To: Amber Willard <[REDACTED]>
Subject: RE: fp/159/20/pun

I attach the plans for proposed extension to the neighbouring property at 36 Blackthorn Avenue.

Roof Plan

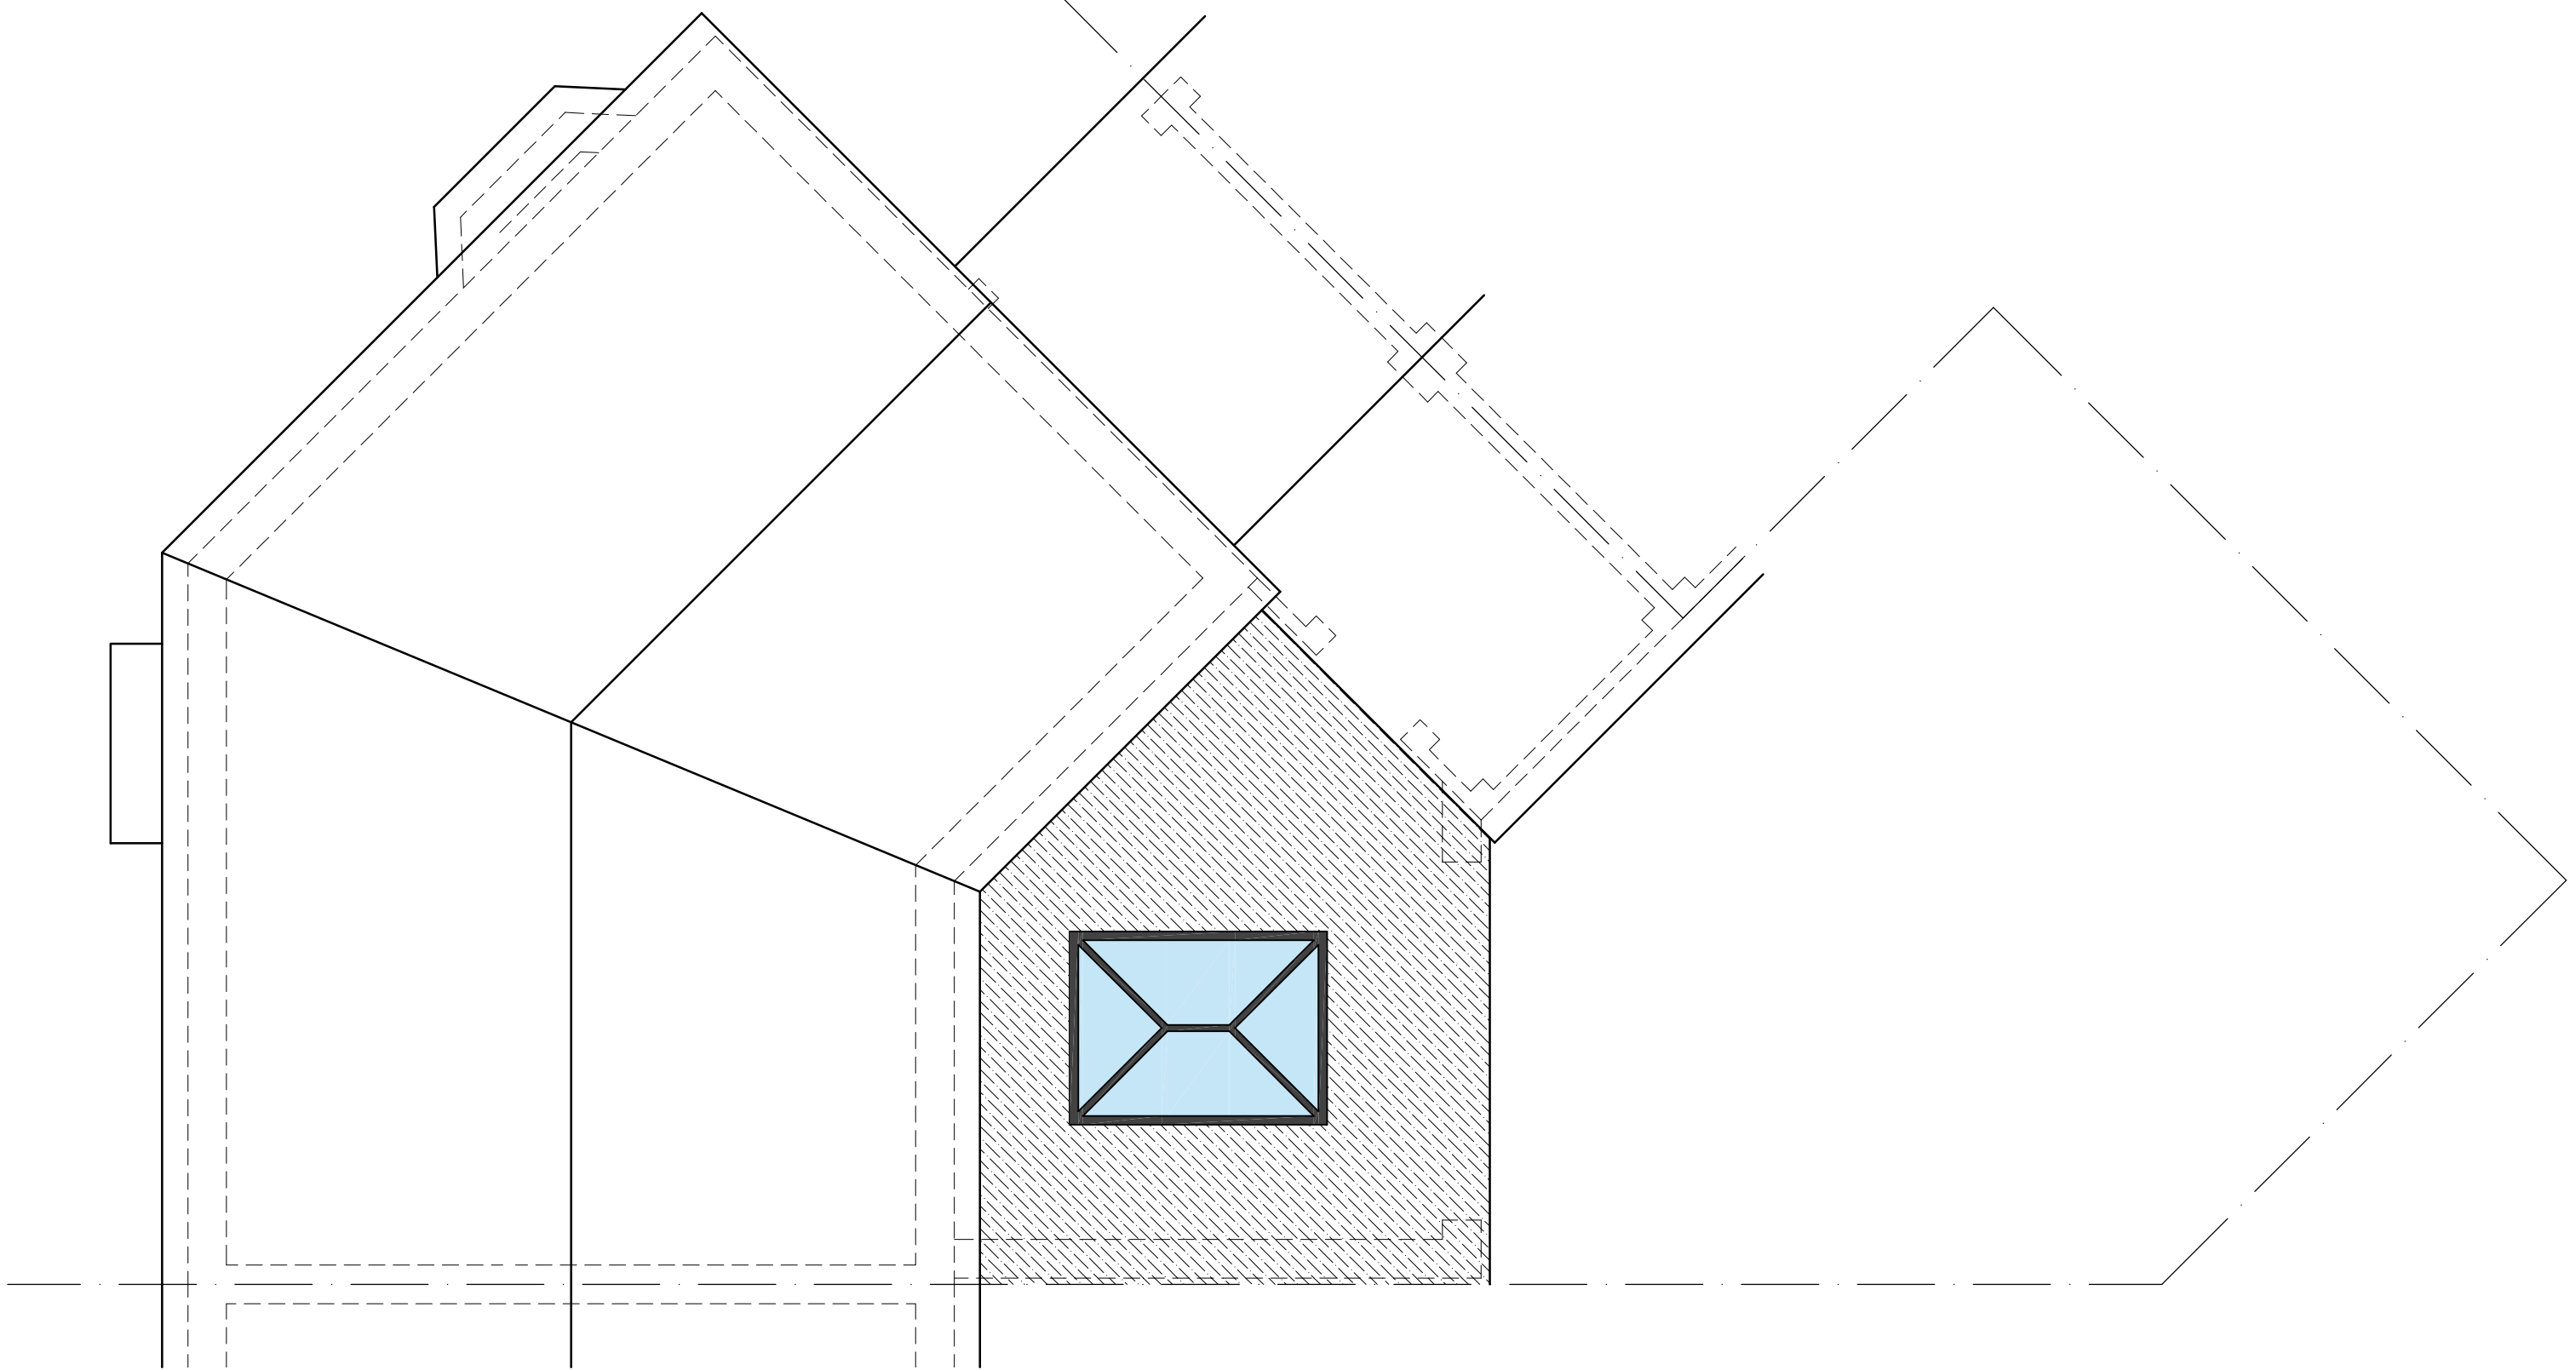
I note that the relationship with our house next door is difficult to judge as very little of it is shown on the plans submitted. In fact the all important eastern elevation of the proposed extension is not shown at all. You can see that our number 35 Blackthorn Ave., is on the inside of a 90 degree bend in the road and is therefore a tiny triangle of back garden with the adjacent boundaries joining at the bottom of the triangle. The boundary between number 35 and 36 does not run away from us parallel to our house, it comes diagonally across our rear garden and if the proposed extension to number 36 was built we would be looking out at an 11ft high brick wall across our line of sight.

Nobody would want to live there hemmed in by a 3m (11 foot) high 4.092m (12ft long) brick wall. Perhaps you could let us know whether there are regulations concerning degrees of sightlines from our windows that are protected?
